East Pye Solar
Written Summary of the Applicant's Oral
Submissions and Responses at Issue Specific
Hearing 1 and Response to Action Points

Planning Inspectorate Reference: EN0110014

Document Reference: EXAM/9.17

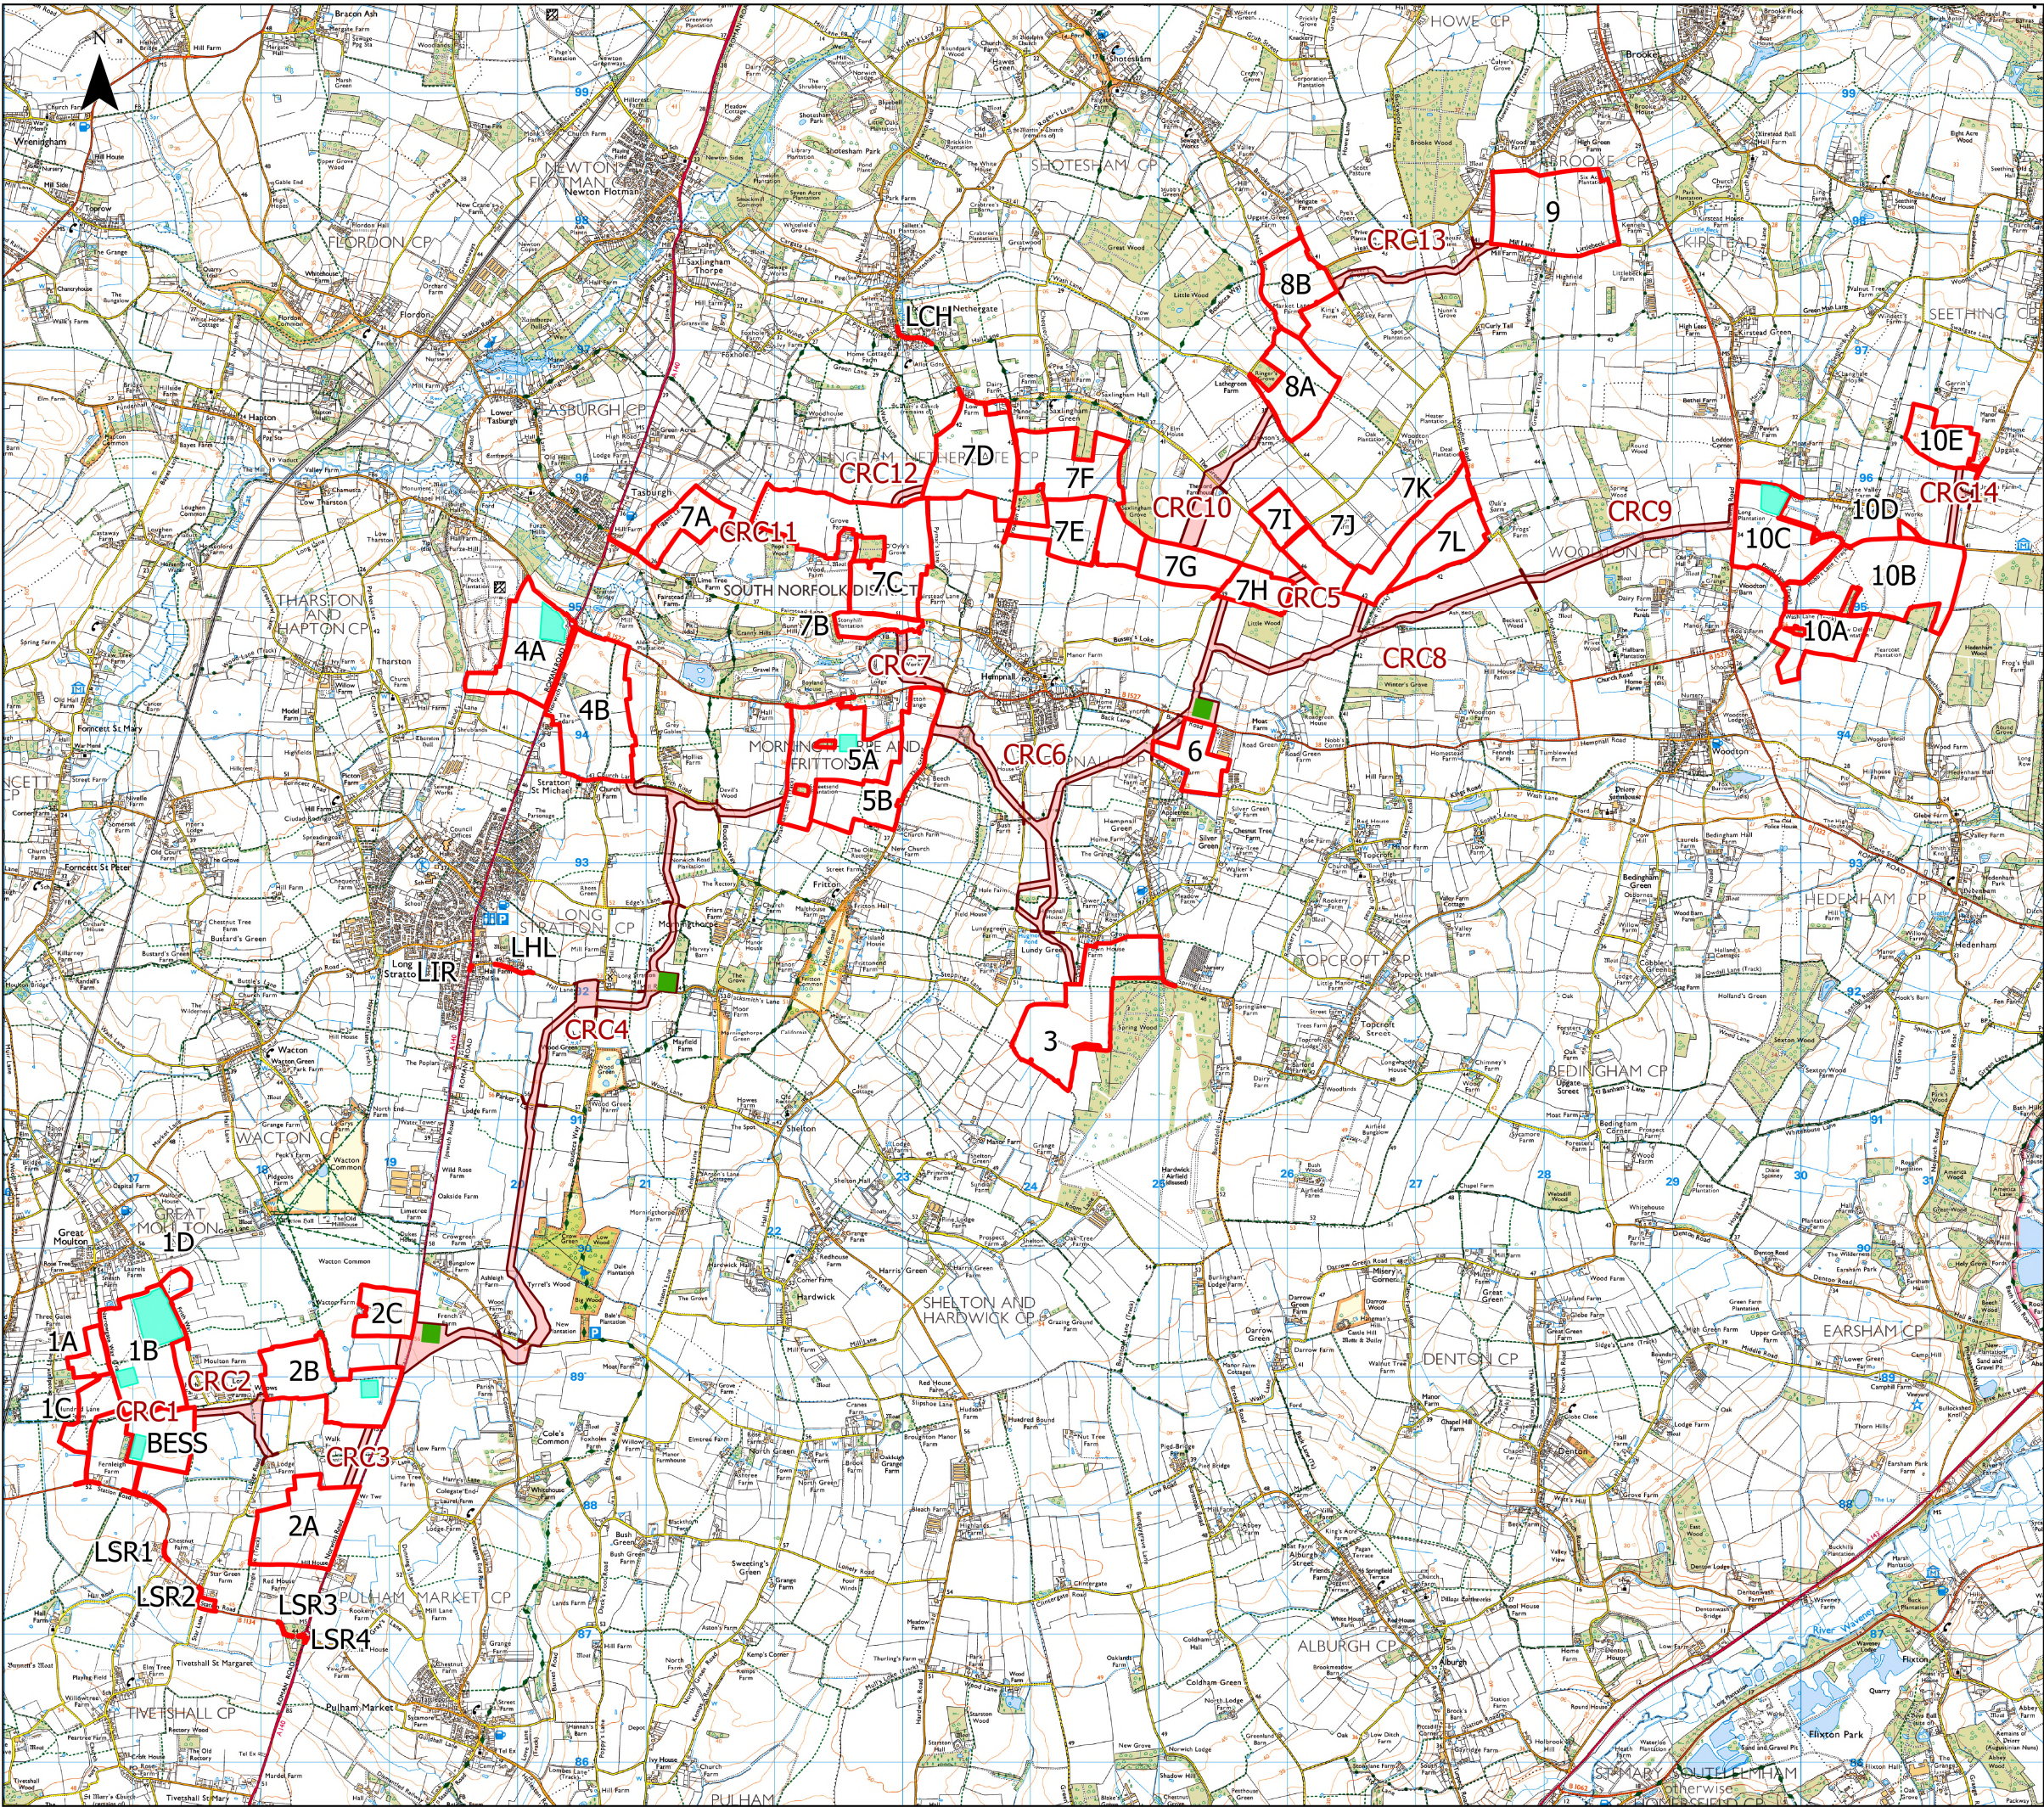
i) Construction compounds (Work No.8)	The ExA asked how the compound locations on ES Volume 2, Figure 4.2 - Indicative Temporary Construction Compound Locations [APP-060] relate to the construction compounds proposed. Mr Douglass explained that they correspond to the Works Plans, under Work No. 6 (Cable Route Corridor) and Work No. 8 (construction compounds within the Site). Asked how long the compounds would be required, Mr Douglass explained that, at present, they would be required for the duration of the construction period (assessed in the ES as two years) and agreed to consider linking this to the phasing strategy. <i>See the Applicant's response to the Actions Point 28, submitted alongside this written summary at Deadline 1.</i> Dr Berry asked about the future replacement of solar panels and which construction compounds would be used.
